From: [REDACTED]
Sent: 31 August 2014 21:14
To: Janice Chapman
Subject: Re: FP/132/14/HH - Erection of a pagoda style carport at 10 Grafton Avenue, Felpham

The application refers to timber supports for the car port but does not make any reference to the roof covering.

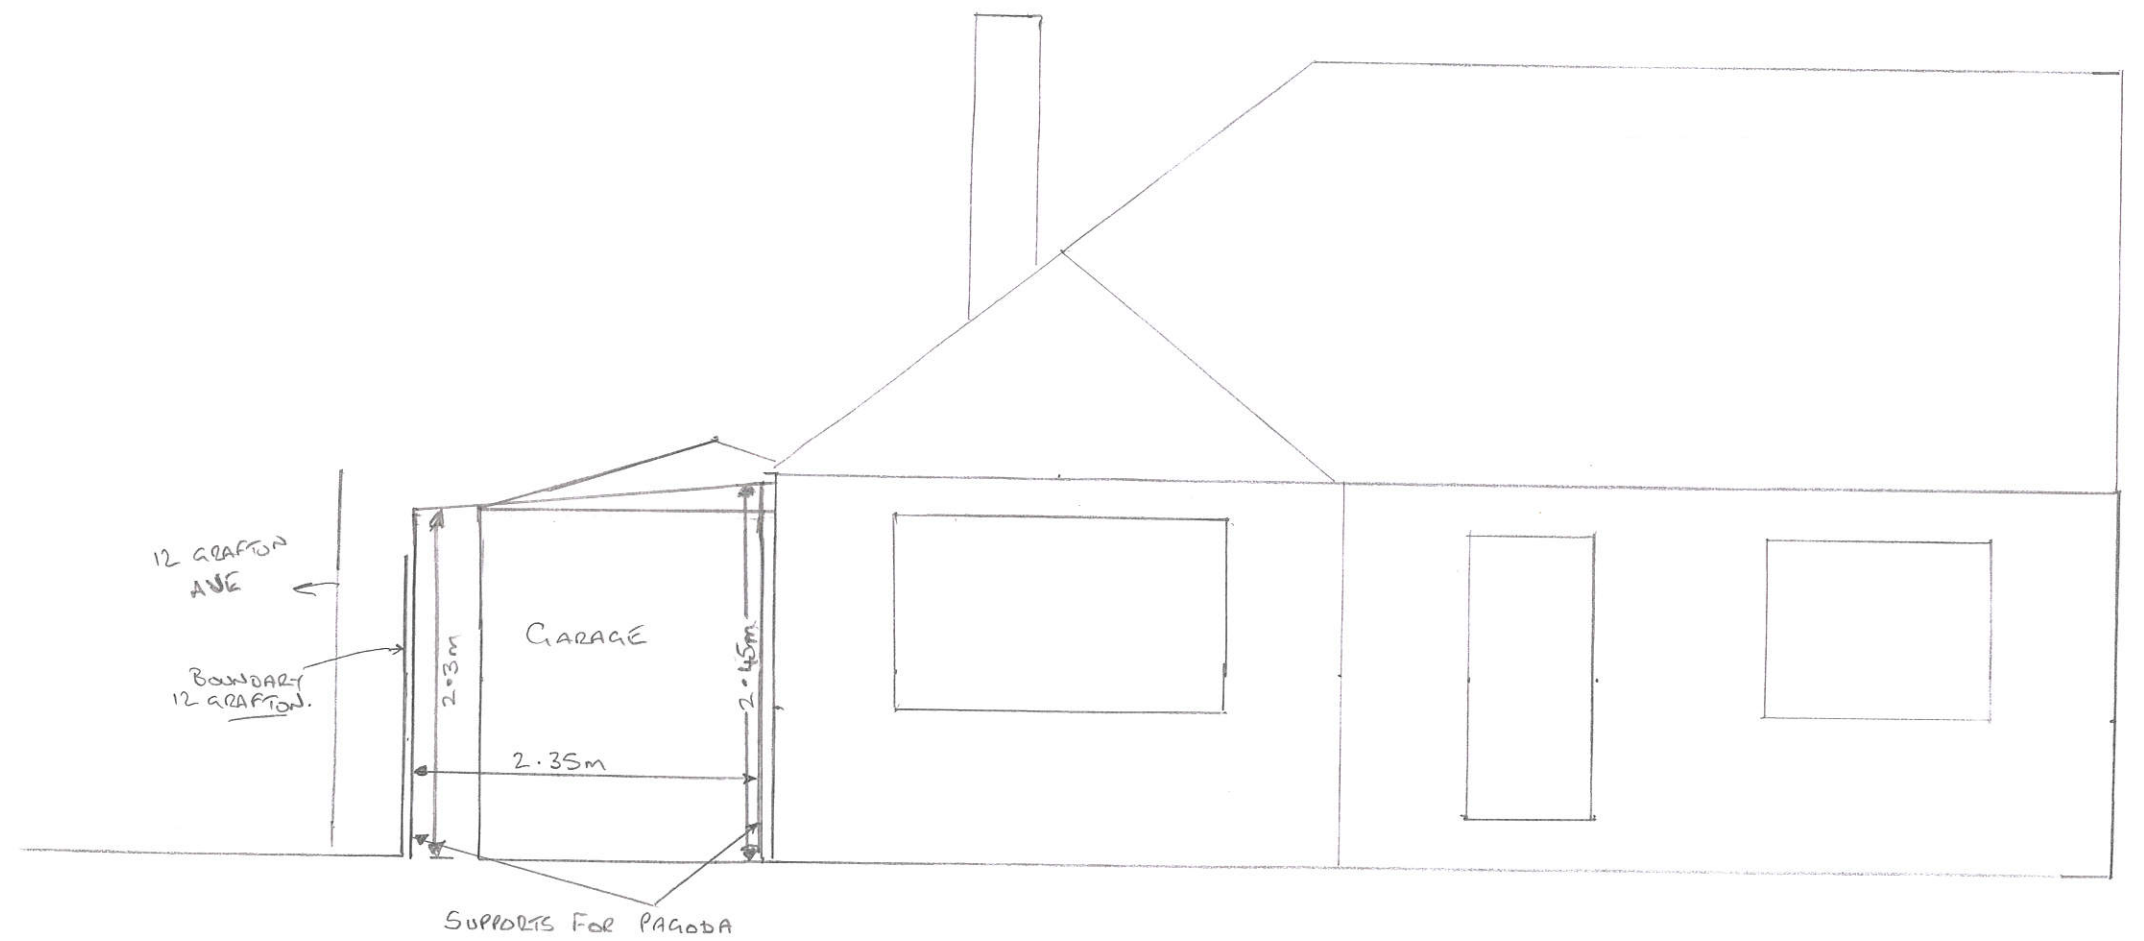
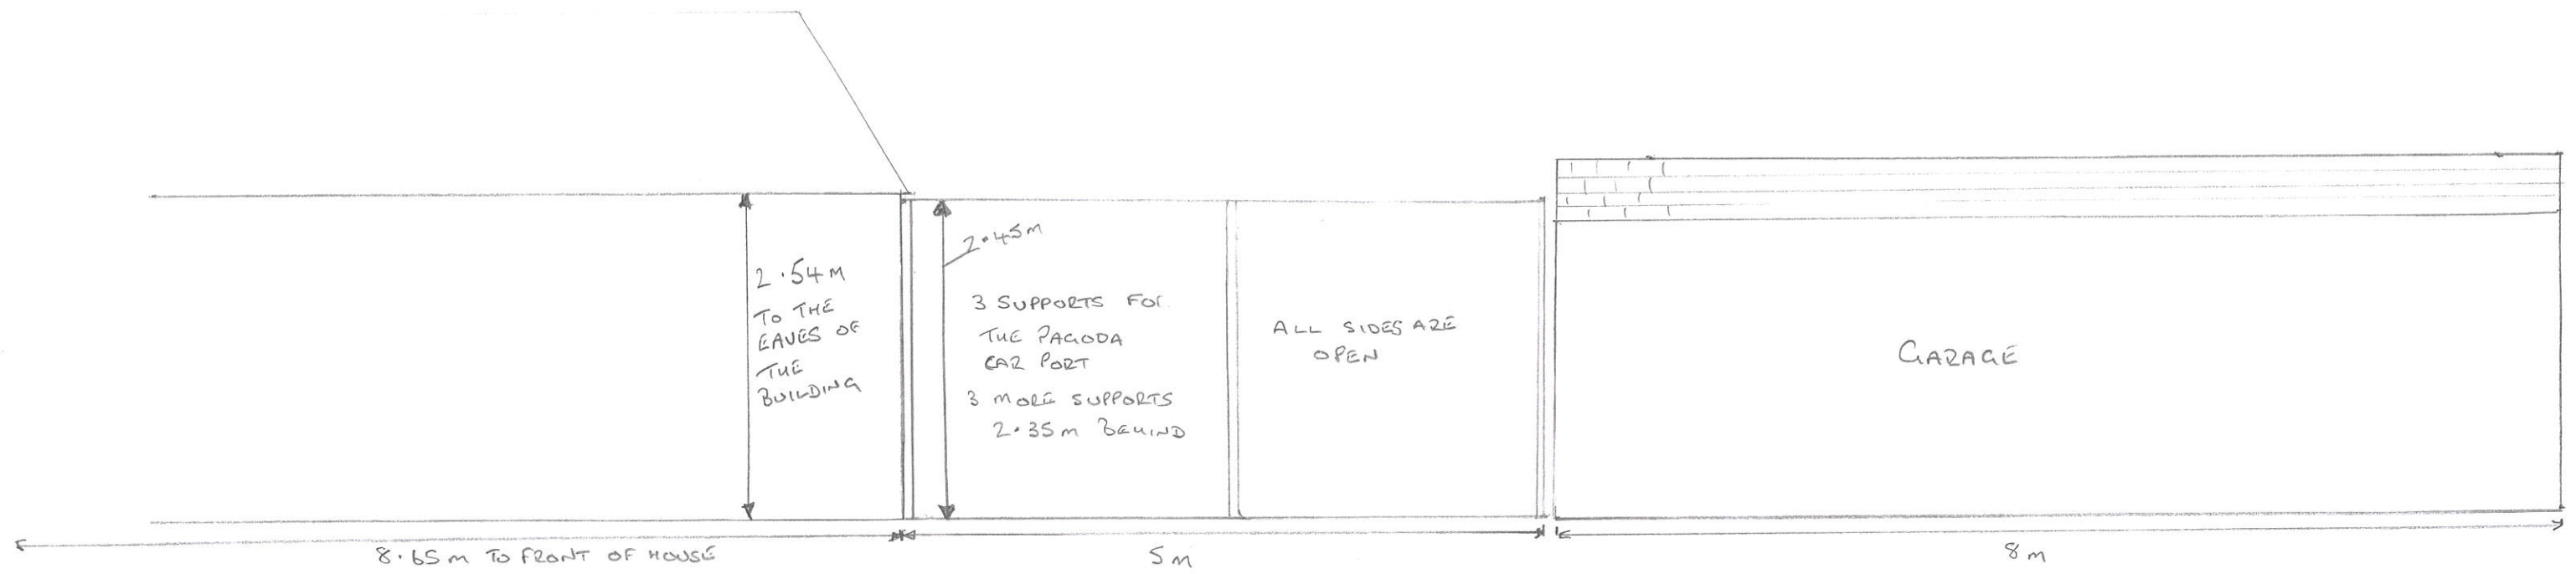
Please confirm.

We can confirm that the roof covering will be polycarbonate sheets, which will be fixed in sections, allowing for those nearest the house to be removable for any maintenance work to the property.

The sheeting will end before the boundary line and drain into guttering, which will be fixed underneath and will connect to the existing garage downpipe.
